23 Ocean Avenue - Final Traffic Comments

Hi Nell – I have reviewed the application materials and offer the following preliminary traffic comments.

REINFORCED CONCRETE DRIVEWAY APRON
NOT TO SCALE

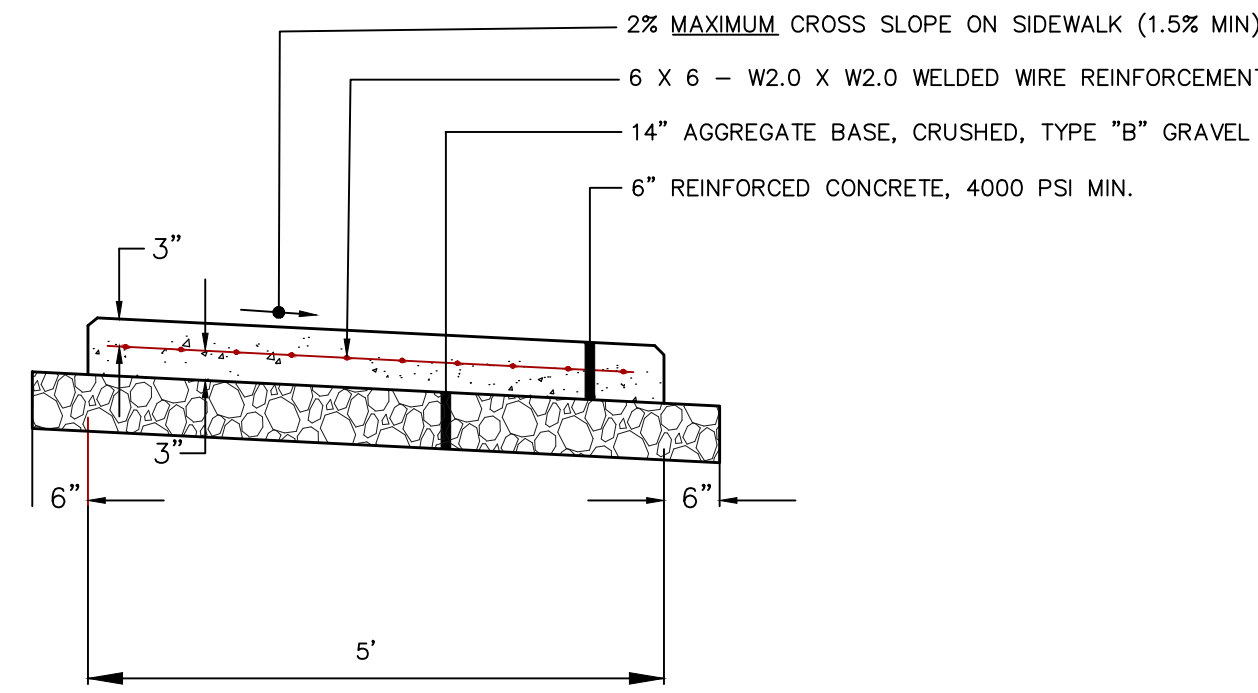
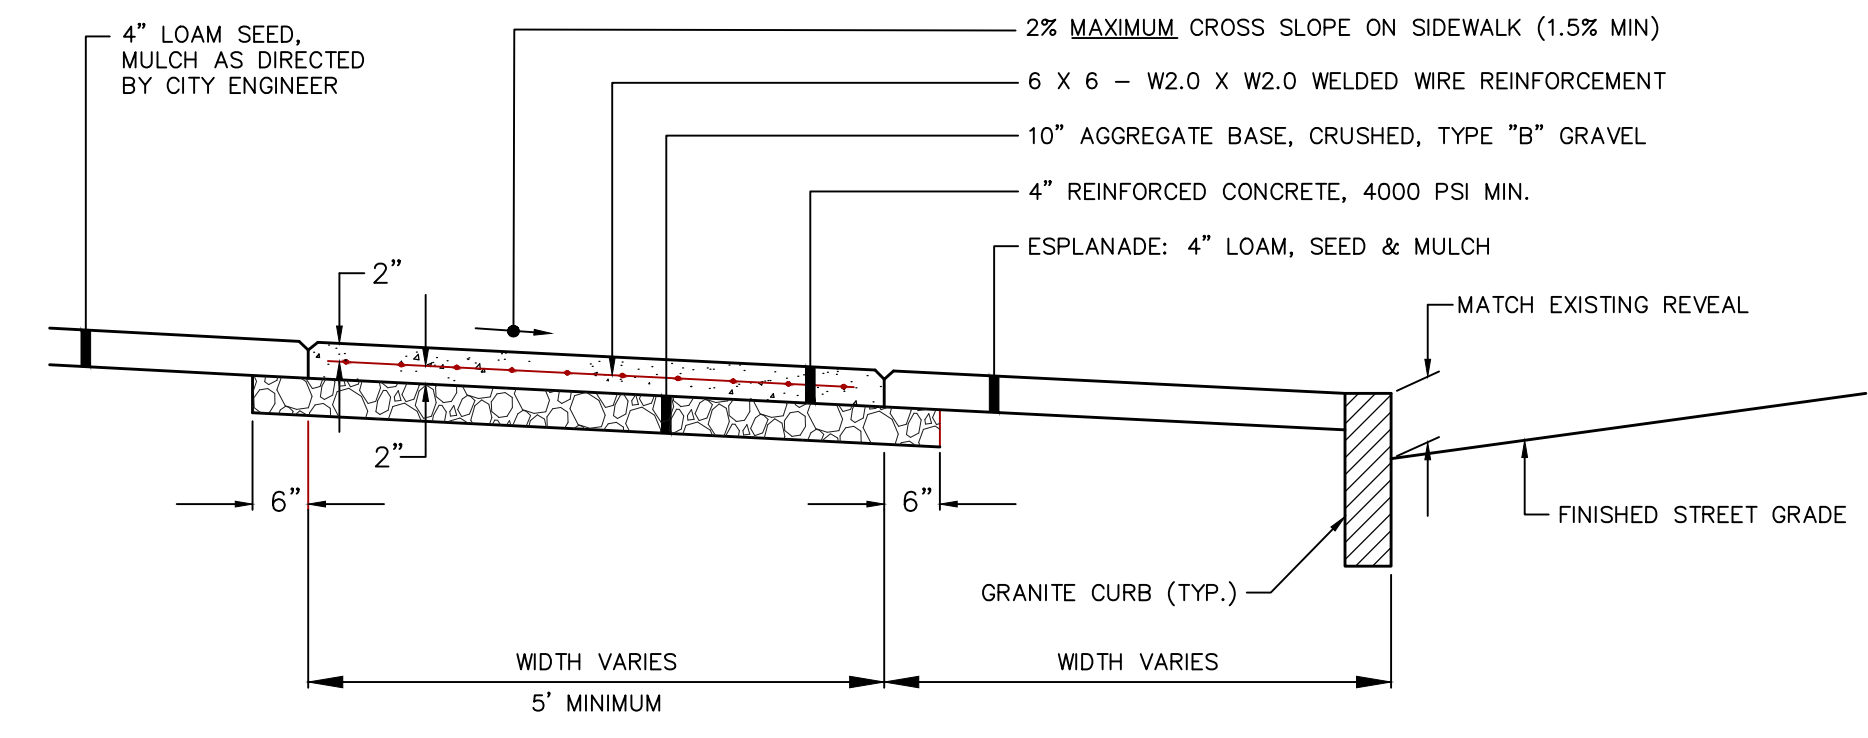
- A detail for the driveway shall be provided that notes that the cross-slope shall not exceed 2%.

Status: The plans have been revised and I have no further comment.

REINFORCED CONCRETE SIDEWALK
NOT TO SCALE

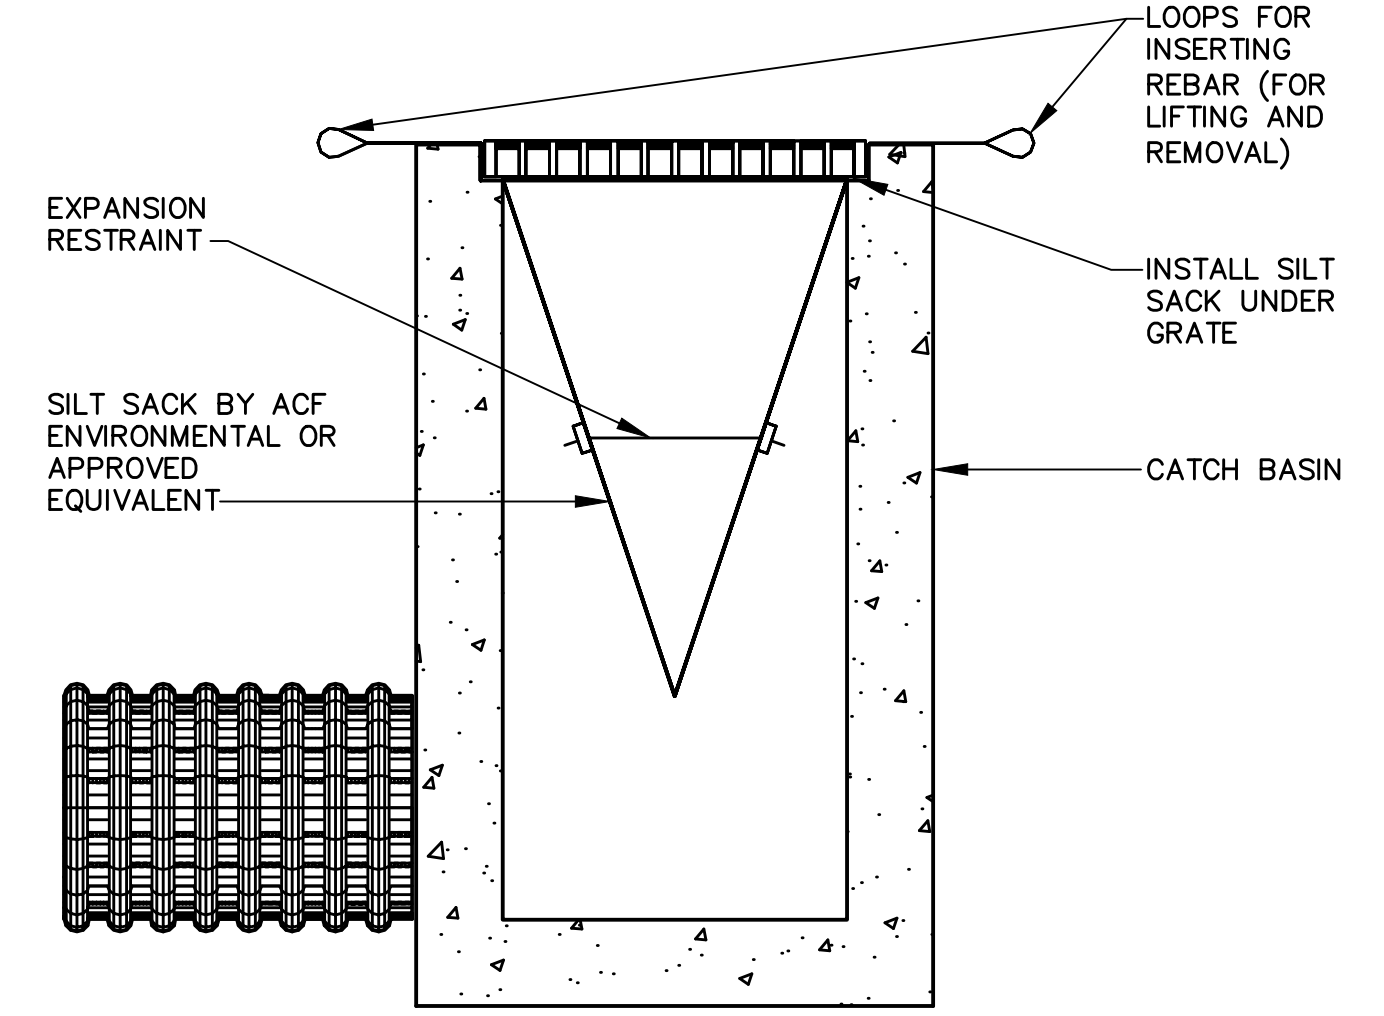
- The plans do not include full replacement of the sidewalk on Ocean Avenue along the entire property frontage. The applicant should either include full sidewalk replacement or document justification for the current proposal.

Status: The plans have been revised and I have no further comment.

3 SIDEWALK RAMP DETECTABLE WARNING TILE AND APEX RAMP
NOT TO SCALE

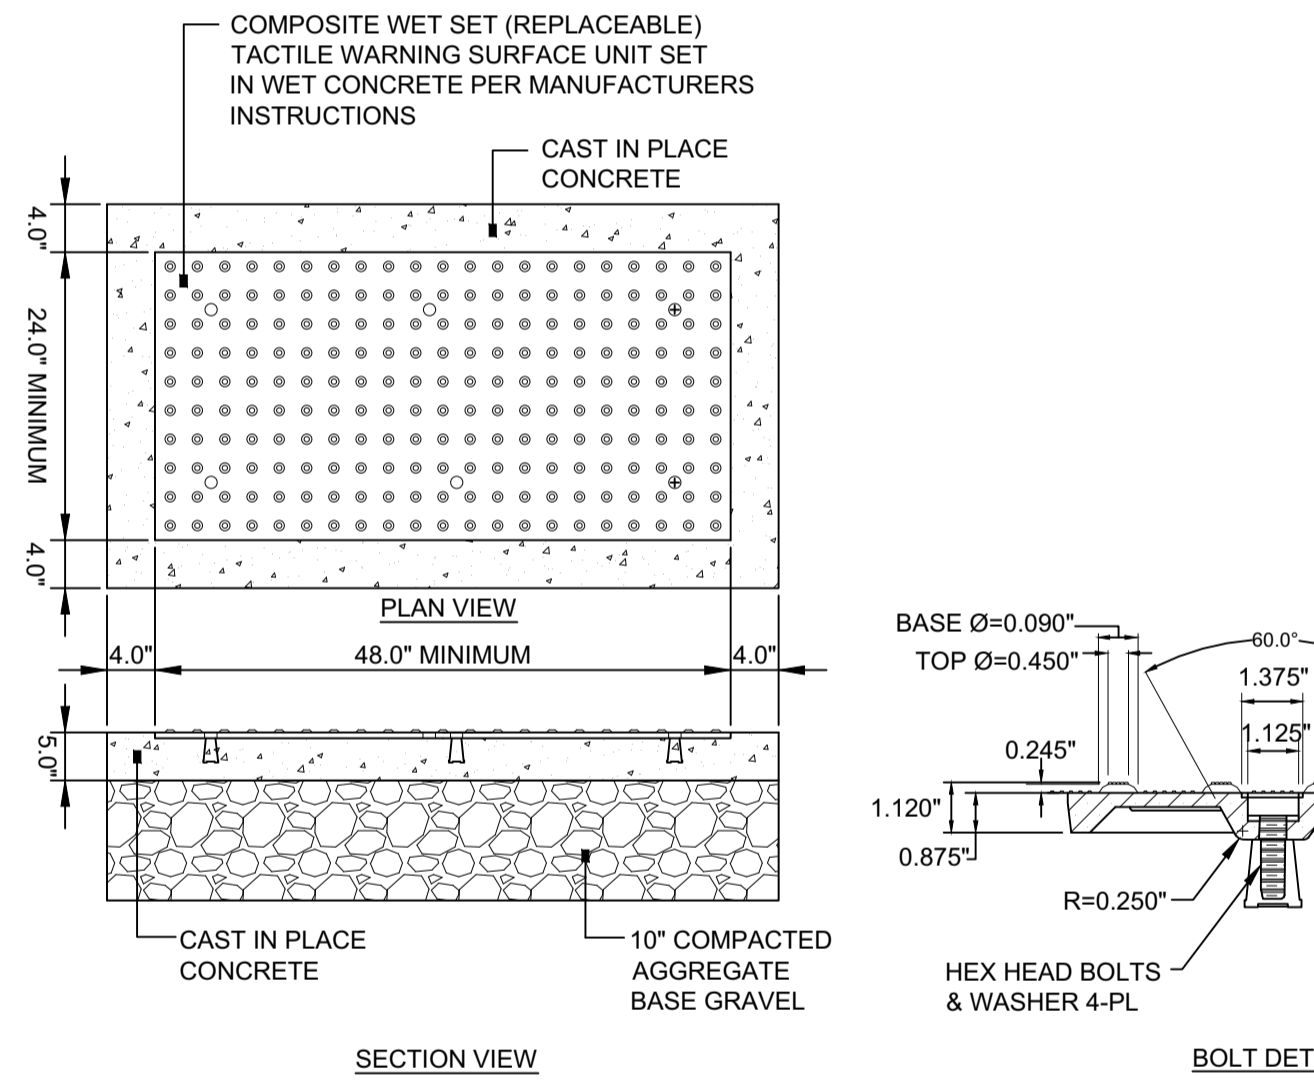
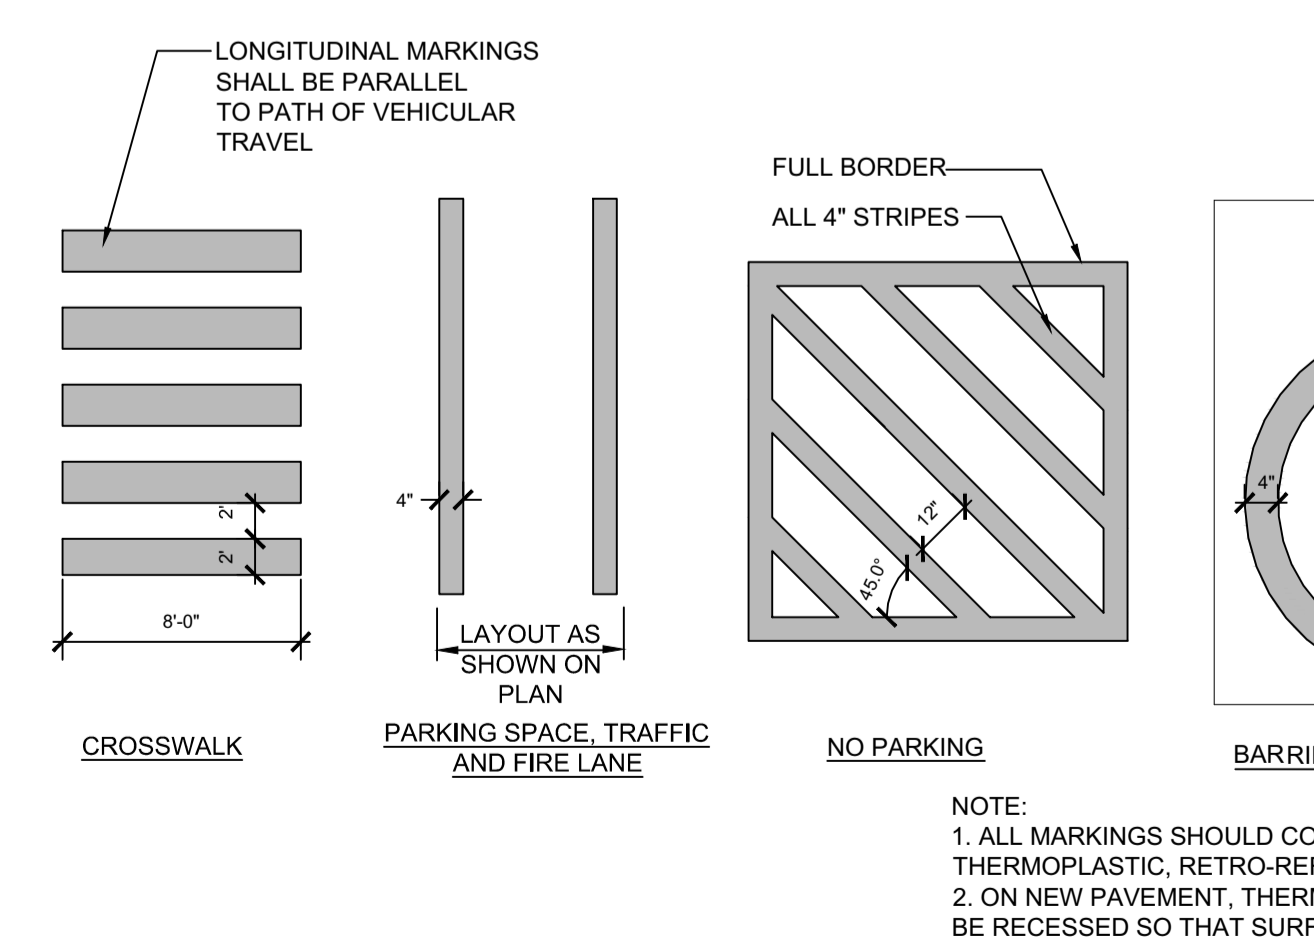
- Further review of the sidewalk ramp configuration is required. I would suggest that a fully ADA compliant ramp be provided on the opposite side of Hersey Street.

Status: The applicant shall upgrade the sidewalk ramp on the opposite side of Hersey Street to meet ADA requirements. The applicant shall submit plans to the City for review and approval. I would note that the City recognizes the right-of-way limitations at the subject corner and will assist the applicant in design development.
